From: Laura Gibbons
Sent: 19 November 2018 09:56
To: Planning.Responses
Cc: Simon Davis
Subject: RE: Planning Consultation on BN/52/18/DOC

Engineers Comments Regarding Condition 4- Surface Water Drainage

APPLICATION **BN/52/18/DOC**
NO:

Registered: 07-NOV-18
Site Address: Land East Of Toll Cottage Lake Lane Barnham PO22 0AD

Drawing Title
Drainage Strategy
Site Location Plan

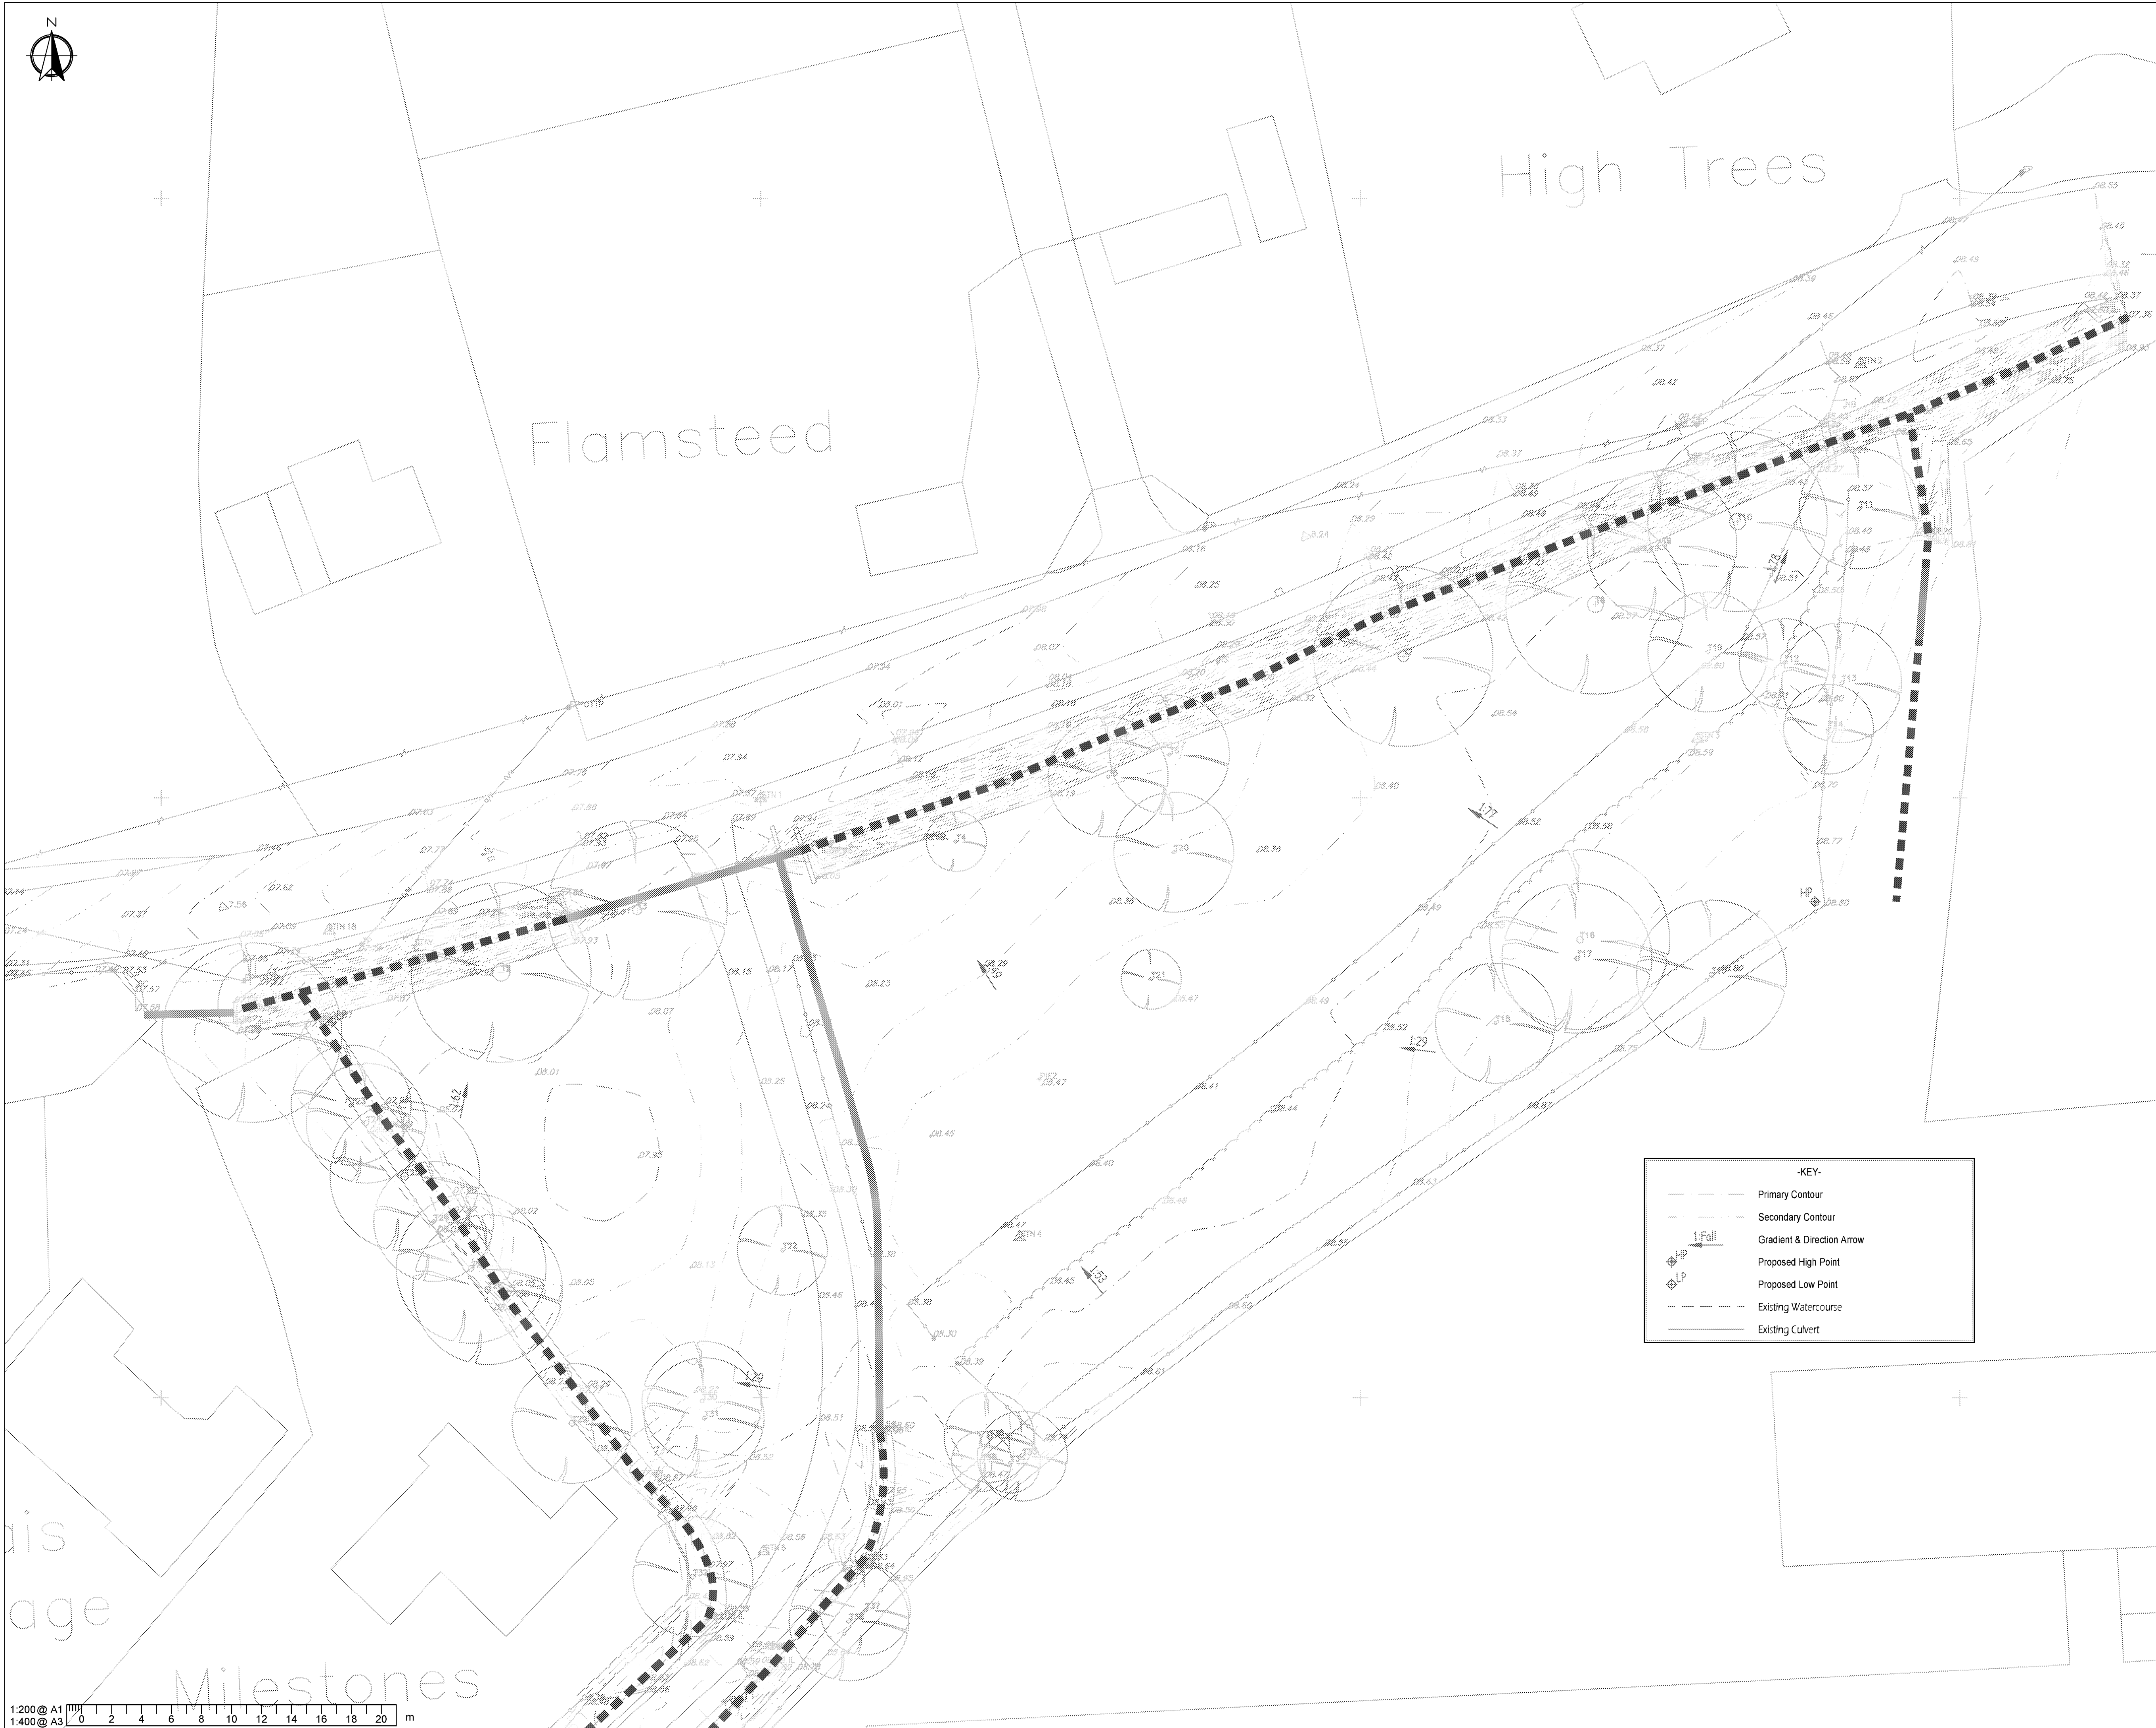
The proposed surface water drainage scheme is for attenuation and controlled discharge to the ordinary watercourse at 5l/s. This is far in excess of the greenfield runoff rate. Please reduce the discharge to 2l/s, this is the minimum flow restriction we accept as a result of risk of blockage at lower rates. Please submit revised layout and calculations.

There does not appear to be 3m easement between watercourse banks and fences. Please provide a plan showing this buffer zone.
